**REQUEST**

Current Zoning: UMUD-O (uptown mixed-use district, optional)  
 Proposed Zoning: UMUD-O SPA (uptown mixed-use district, optional, site plan amendment)

The petition proposes to allow up to three electronic changeable copy signs totaling a maximum of ~~5,900~~ **4,800** square feet. The site is developed with a mixed-use office tower.

II. Optional Provisions for UMUD-O:

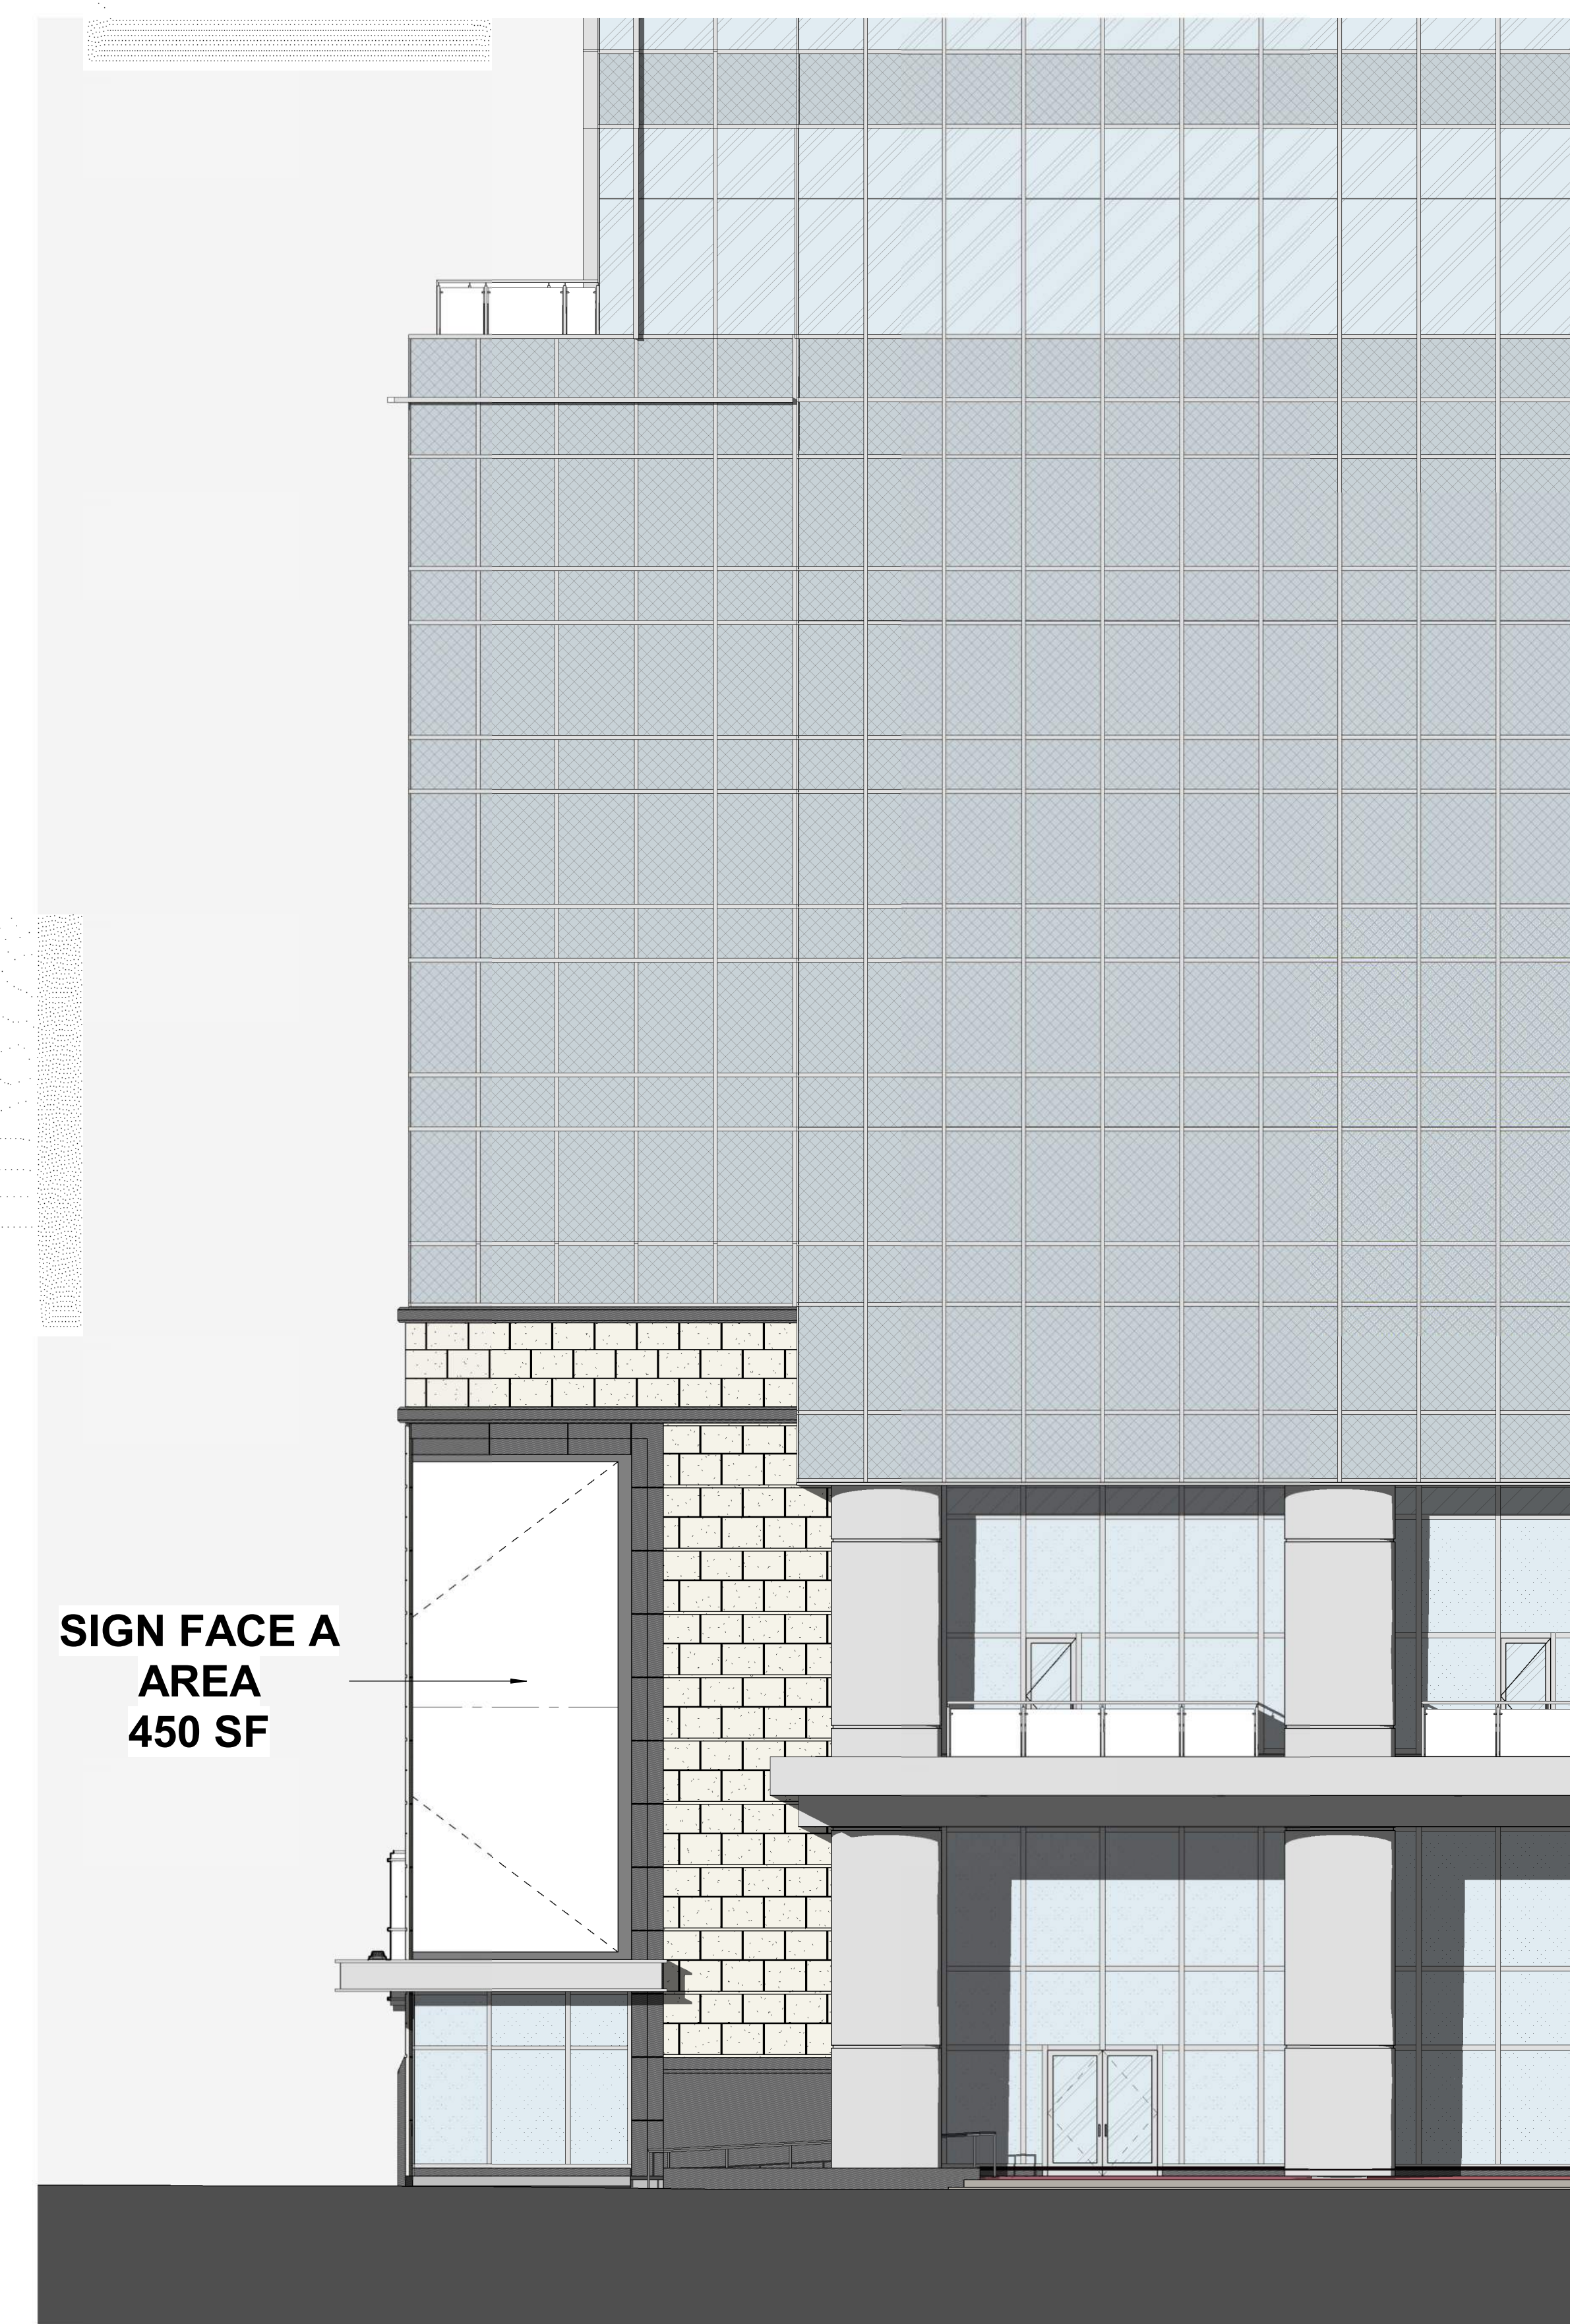
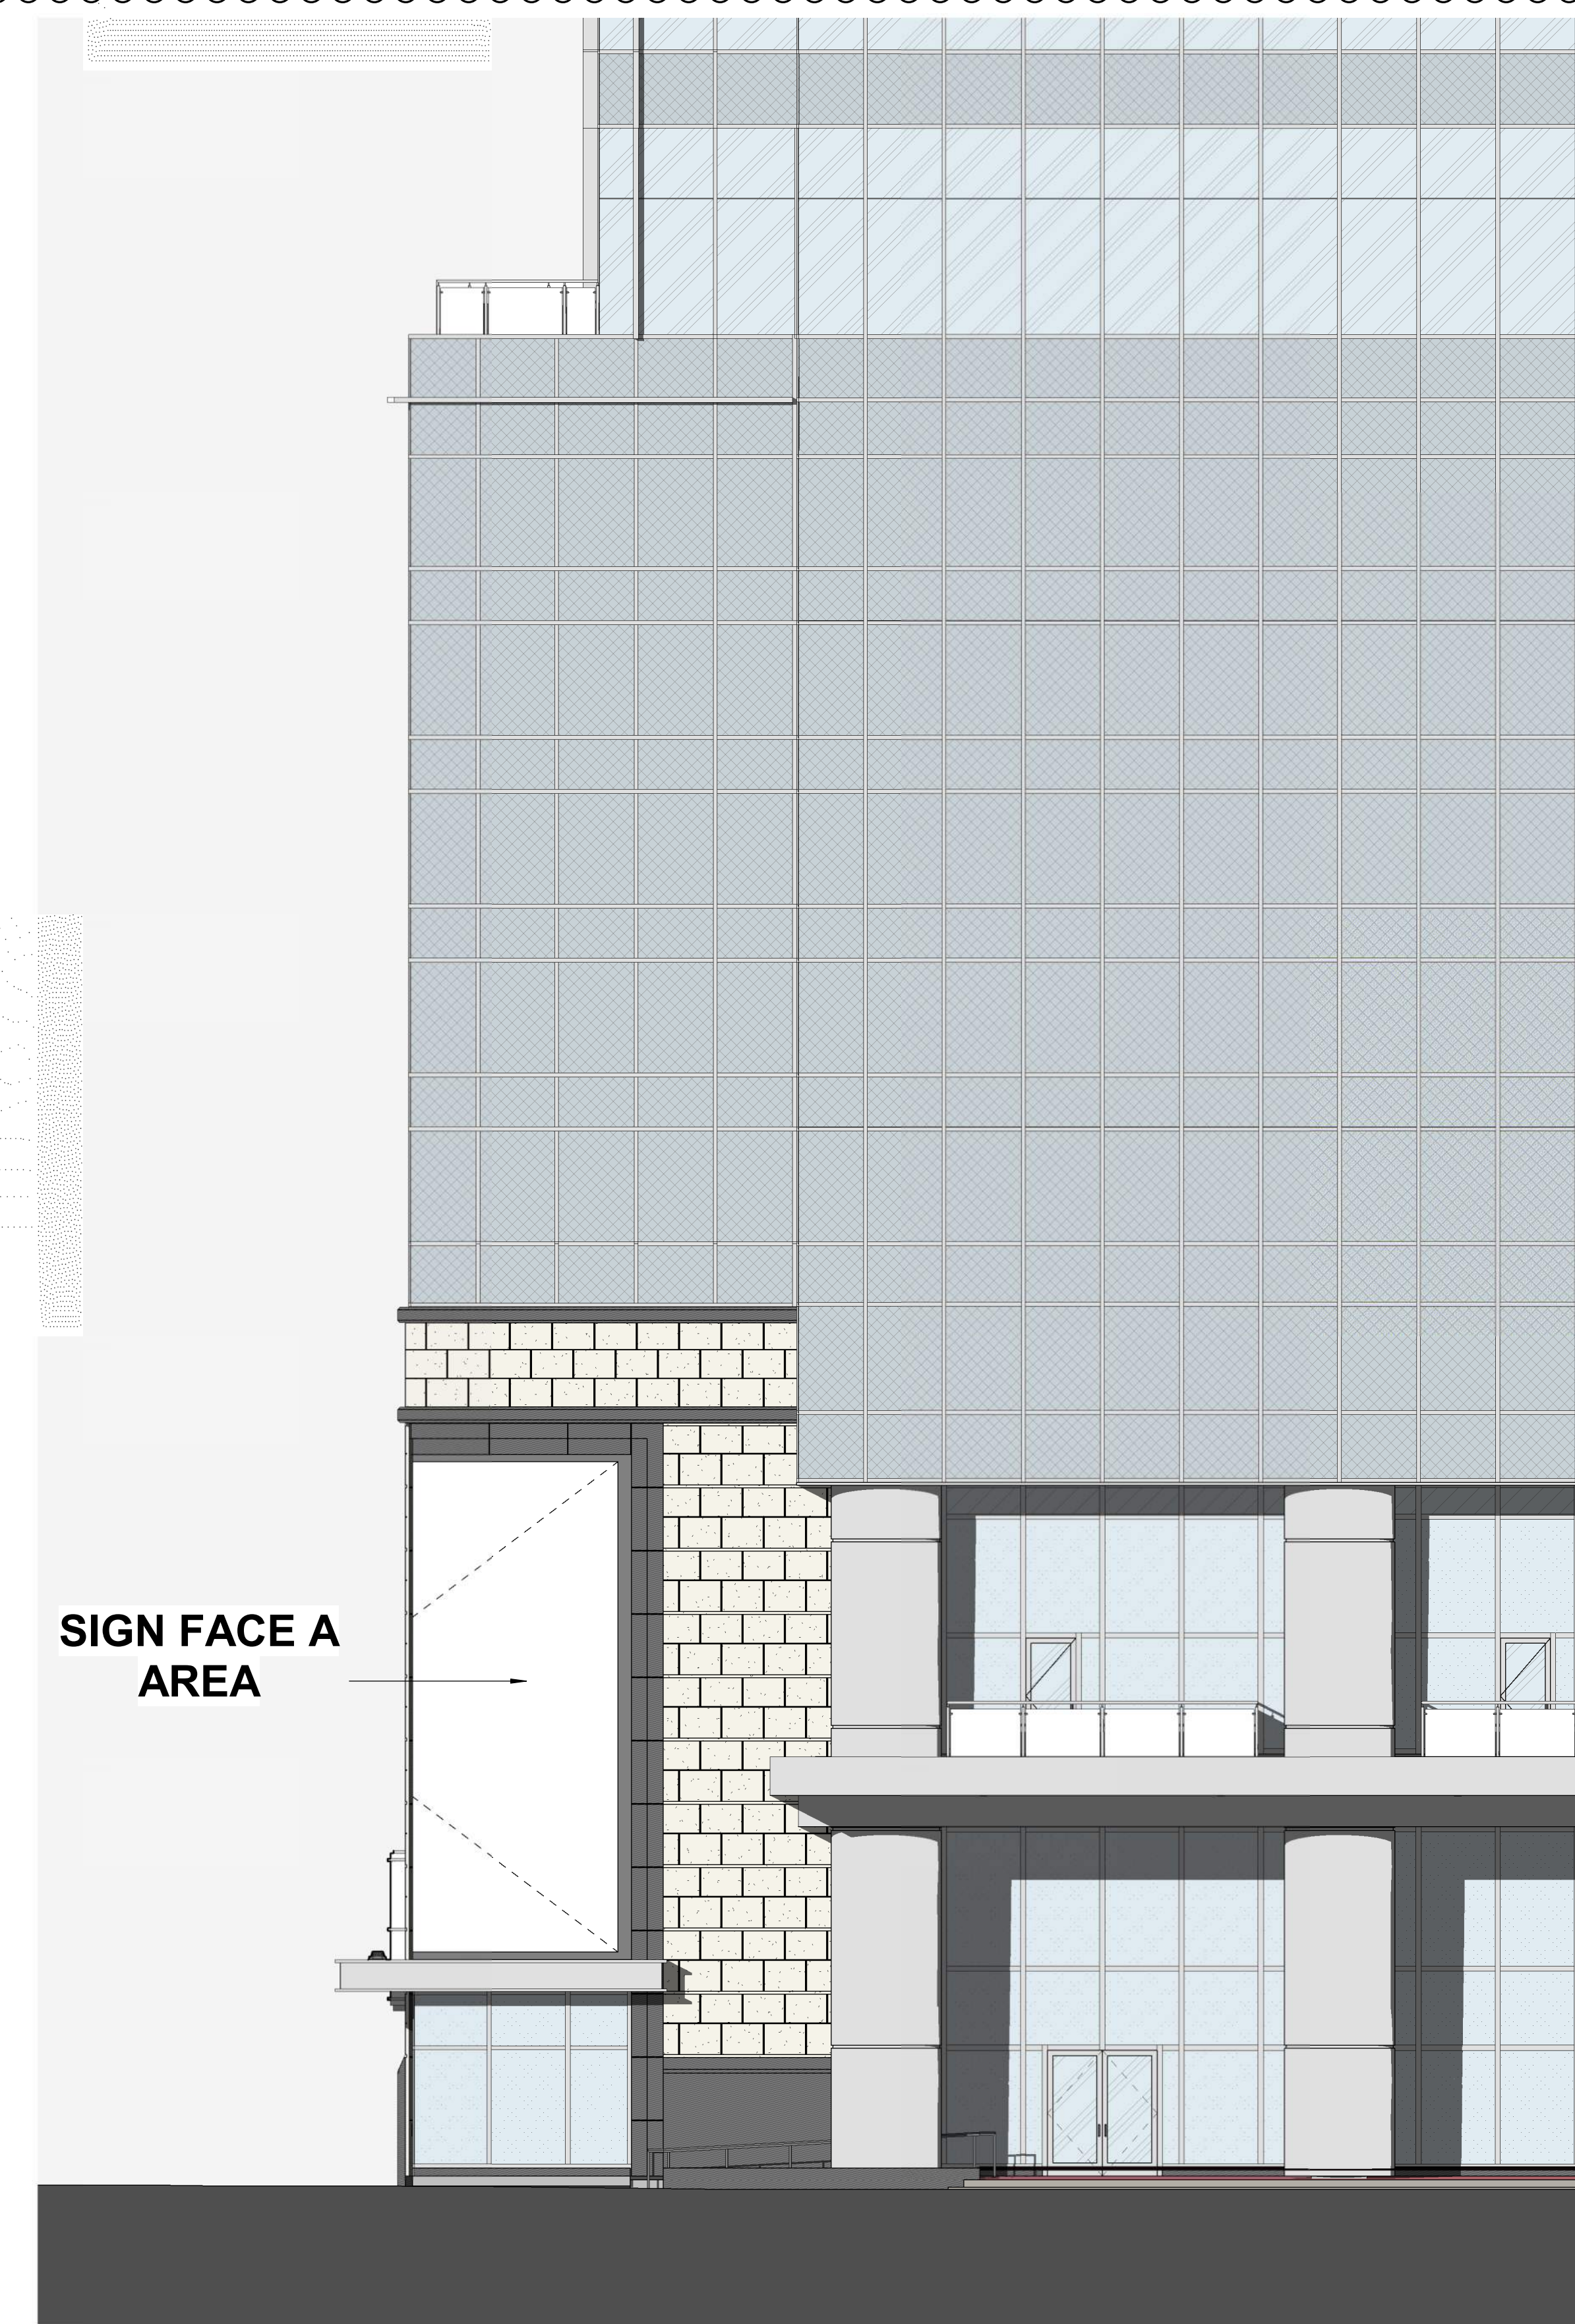
- ~~1. The language of the proposed optional provisions should be updated to describe the requested signage as wall signs in accordance with the standards Chapter 13 of the Zoning Ordinance.~~

**ADDRESSED**
